Date: 3 October 2023
Our Reference: 23/06121/PHMT

Remove existing garage, extend the existing property over 2 floors to depth of existing conservatory to the rear & side. Set away from the existing boundary, provide new entrance porch. at 199 Ongar Road Brentwood Essex CM15 9DU

2023.623.01: Site and Block Plan
2023.623.02 : Existing
2023.623.03 : Proposed Floor layout
2023.623.04: Proposed elevations

Dwg No :
2023.623.04

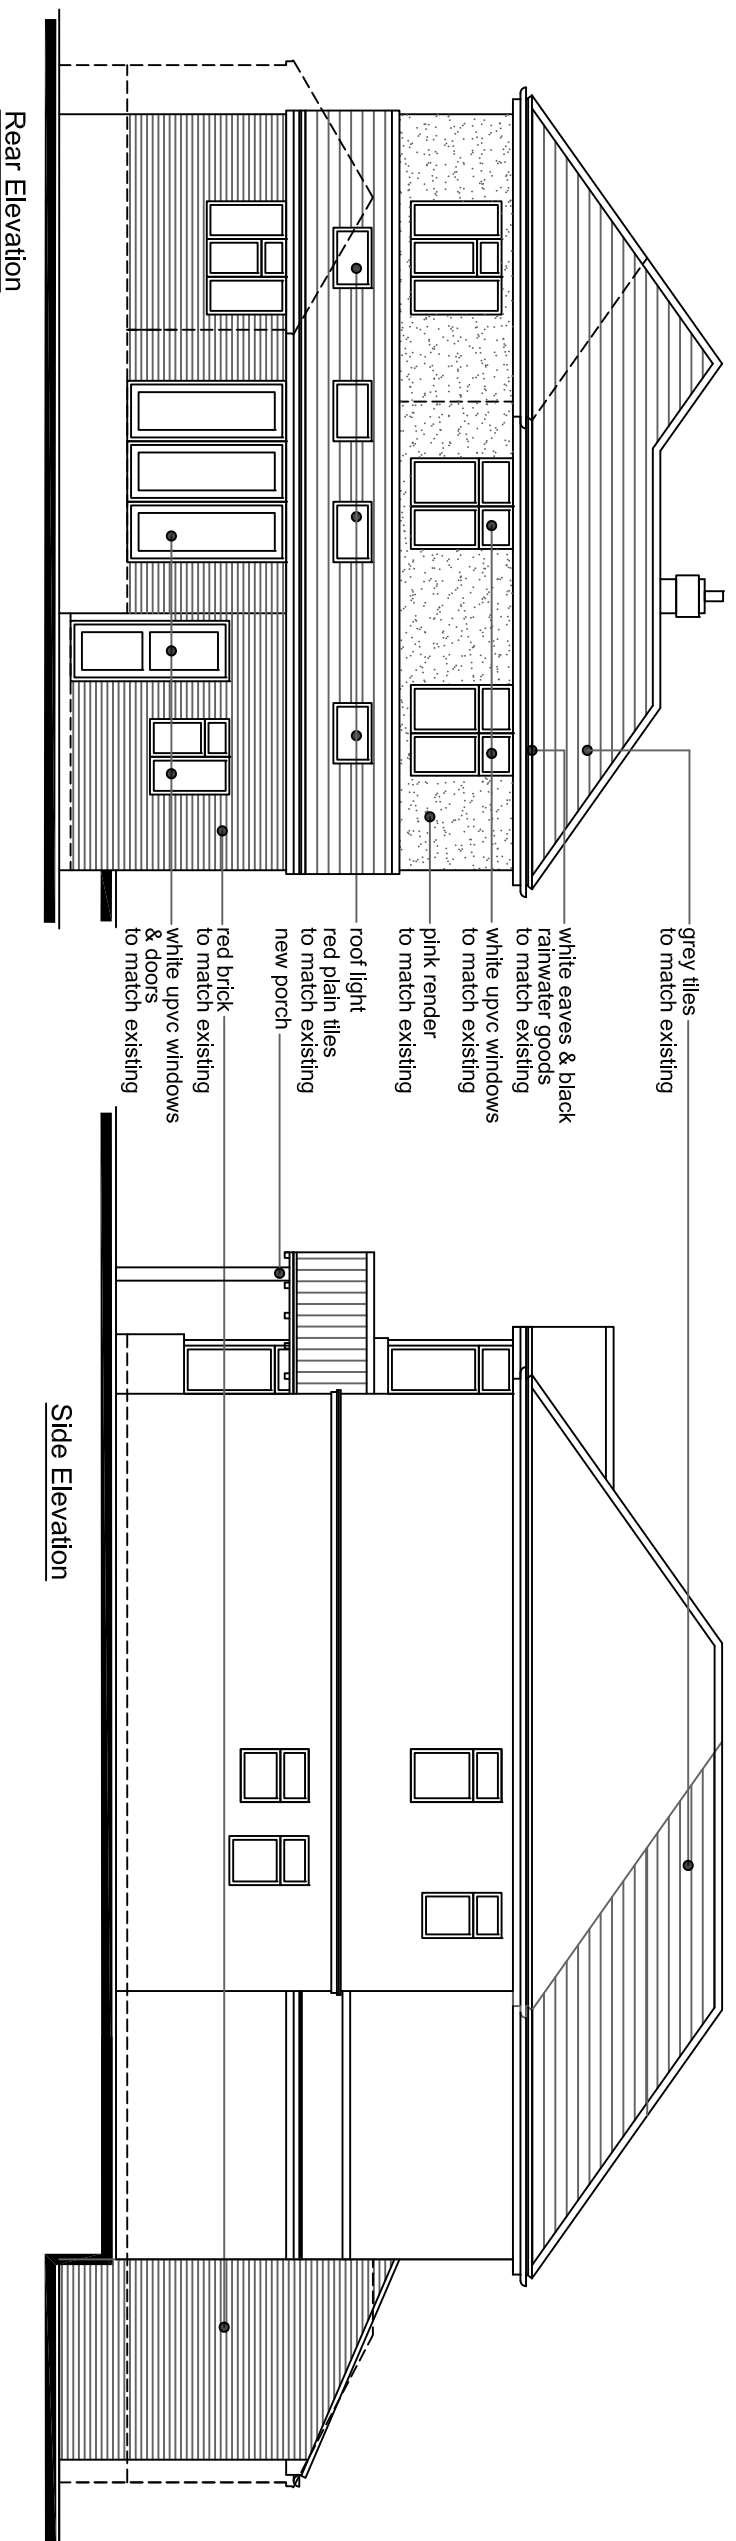
Original proposals sought to add a two storey side extension set back from the front building line by approx 3.5m with a hipped roof design and central crown roof which is set down from the main ridge. A two storey front gable bay window is proposed which is in keeping with the existing dwelling. The proposal continues through to the rear elevation, wrapping around at the rear at first floor level over the existing dining room area. A further 3m deep single storey extension spans across the whole rear elevation which is slightly stepped where the conservatory replacement is proposed. This single storey element has differing roof designs with a flat roof with roof lanterns and a gable design replacing the existing conservatory.

Discussions on site raised concerns that due to the varying ground levels and the height of the single storey elements adj to No 197. The proposals have a raised floor level compared to the natural ground level, therefore issues could arise meeting the 45 degree guidance. Suggestions were made to possibly step the proposal in, along the flank wall and reduce the height. Plus removal of the crown roof as these are not considered as good design, with suggestions of a double hip.

In terms of materials the existing dwelling is currently a mix of red brickwork and pink render at first floor level, drawings detail this appearance would be retained in keeping which is found acceptable.

A front porch canopy is proposed to the existing main entrance with a gable roof which is of a design in keeping with dwelling.

Revised drawings have now been received amending the roof design to a double hip, plus stepping in the rear element Adjacent to No. 197 continuing the flat roof across the whole rear elevation. The revisions have been assessed and it would appear the proposals, in relation to No 197 would comply with the 45 degree guidance. These revisions are found acceptable and the proposals, in my opinion would receive a favourable decision.
